APPLICATION NO. 04DRB-01084	PROJECT NO. 1003544	RAA
PROJECT NAME ROSSITER ADDN, LOT # 77		
EPC APPLICATION NO. -		
APPLICANT / AGENT BILLY W. BACA (APPL.)	PHONE NO. 345 1983	
ZONE ATLAS PAGE G-14	FAX 345-0398	
(SDP for SUB), (SDP for BP), (FINAL PLATS), (MASTER DEV PLAN), (IR), (AA)		
ONE STOP COMMENT FORM LOG

DRB Project Case # 1003544
 Subdivision Name Rossiter Addn Lots 77A + 77B
 Surveyor Anthony L Harris
 Company/Agent Harris Surveying Inc
 Contact Person Billy Baca Phone # 345-1983 email _____

DESCRIPTION OF REQUEST: To divide Approx 14000sq. Ft. @ R-1 Property into 2 Lots of Approx 7000 sq. Ft. each. PRELIM & FINAL

PLAT OF LOTS 77-A AND 77-B ROSSITER ADDITION

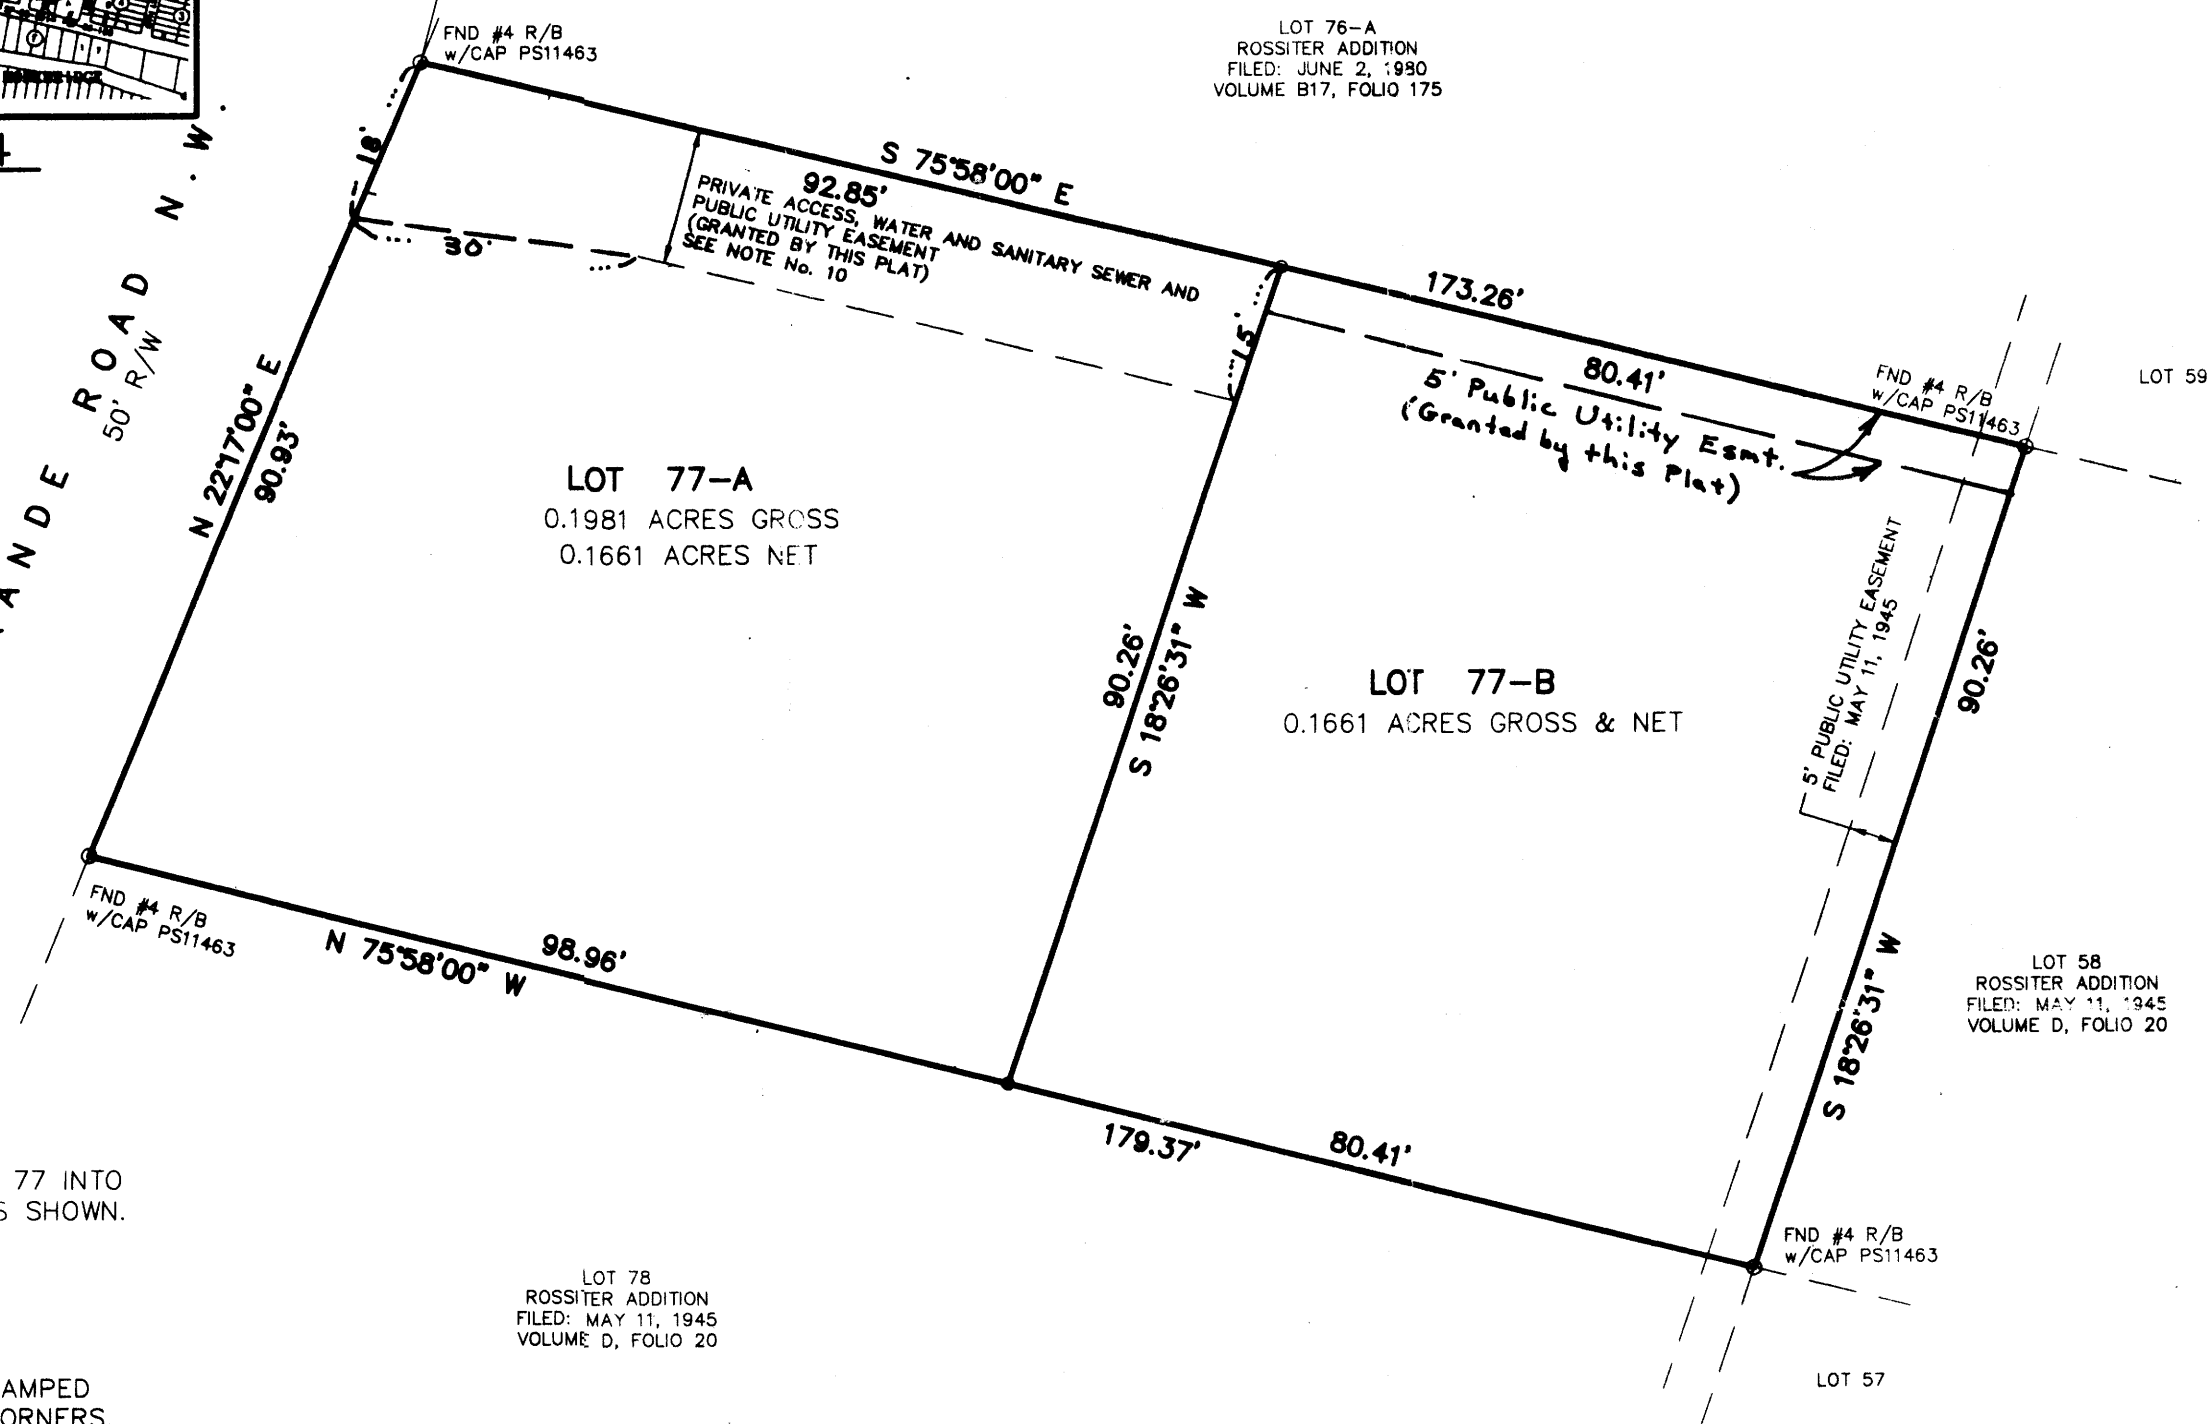
HYDROLOGY DEV (505) 924-3986			
PLANS DISAPPROVED	BLB	DATE 7/13/04	DATE
PLANS APPROVED	BLB	DATE 7/26/04	DATE
COMMENTS:			
Need cross-lot drainage easement

UTILITY DEV (505) 924-3989			
PLANS DISAPPROVED	RLB	DATE 7/13/04	DATE
PLANS APPROVED	RLB	DATE 7/26/04	DATE
COMMENTS:			
① Water & Sewer easement must be billed as "private" and have maintenance and beneficiary statement.

TRANSPORTATION DEV (505) 924-3990			
PLANS DISAPPROVED	HG	DATE 7-12-04	DATE
PLANS APPROVED	HG	DATE 7-23-04	DATE
COMMENTS:			
① HOW X-SECTION OF GRADE ROAD IN RELATION TO PROPERTY LINE. ok			
② WHERE ARE NEAREST DRIVE PADS ON LOT TO NORTH? ok			
③ PRIVATE ACCESS SHOULD BE GRAVELLED w/ INITIAL 25' PAVED.

PARKS AND REC (505) 768-5328			
PLANS DISAPPROVED	CS	DATE 7/13/04	DATE
PLANS APPROVED	CS	DATE 7/23/04	DATE
COMMENTS:			
Need CIL for park dedication. I will send deposit slip when ready.

PLAT OF
LOTS 77-A AND 77-B
ROSSITER ADDITION

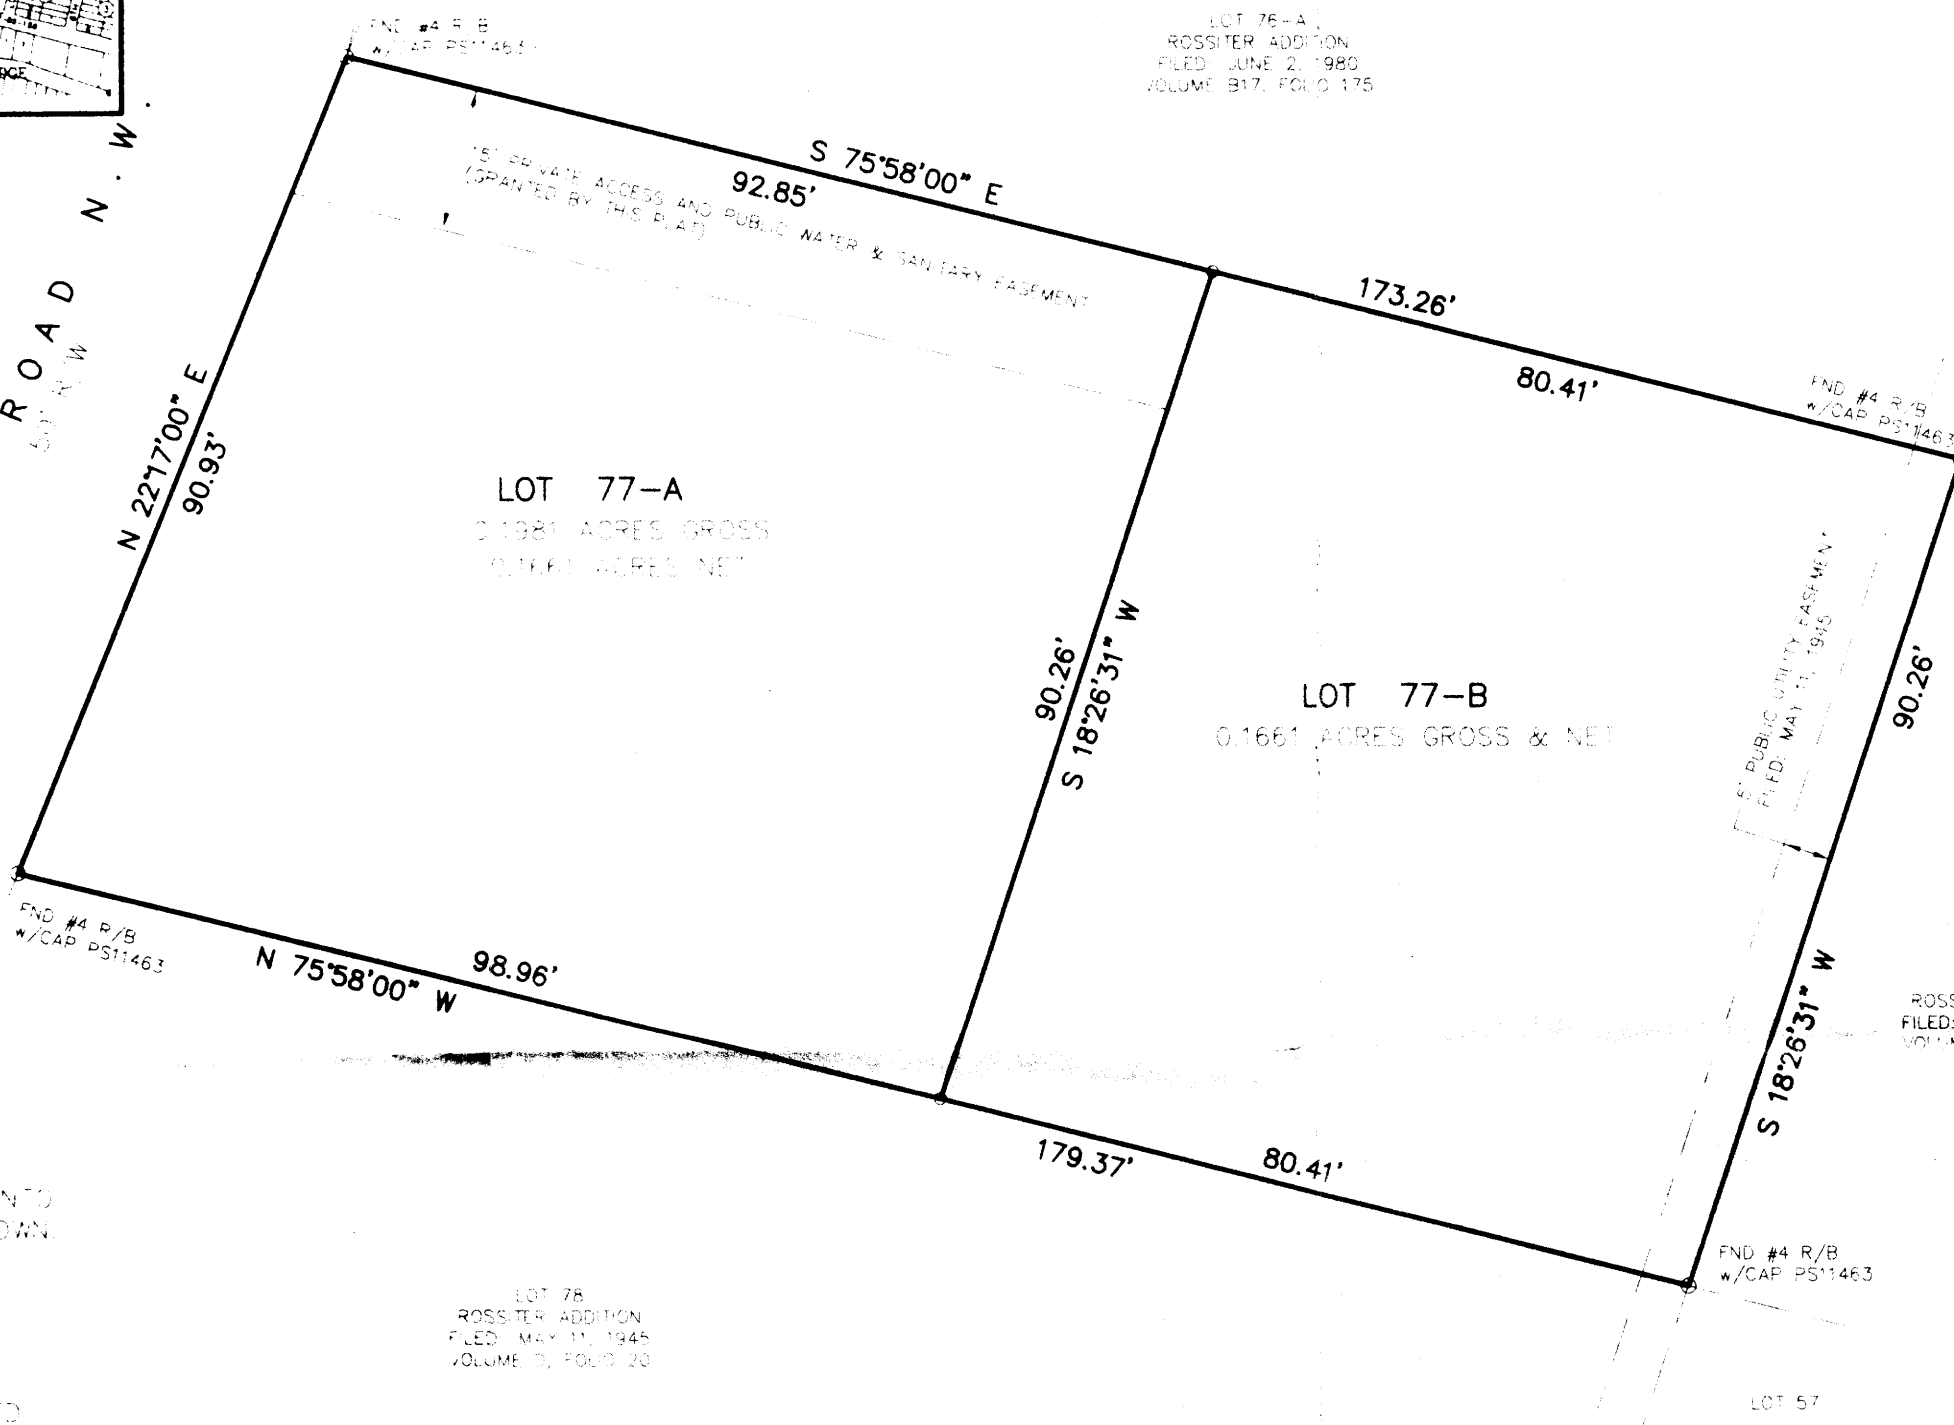
HYDROLOGY DEV (505) 924-3986		
PLANS DISAPPROVED <i>BLB</i>	DATE <i>7/13/04</i>	DATE
PLANS APPROVED	DATE	DATE
COMMENTS:		
<i>Need cross-lot drainage easement</i>

TRANSPORTATION DEV (505) 924-3990		
PLANS DISAPPROVED <i>WG</i>	DATE <i>7-12-04</i>	DATE
PLANS APPROVED	DATE	DATE
COMMENTS:		
<i>(D HAND) Y-SECTION OF BRIDGE PAVED IN RELATION TO PROPERTY LINE.</i>
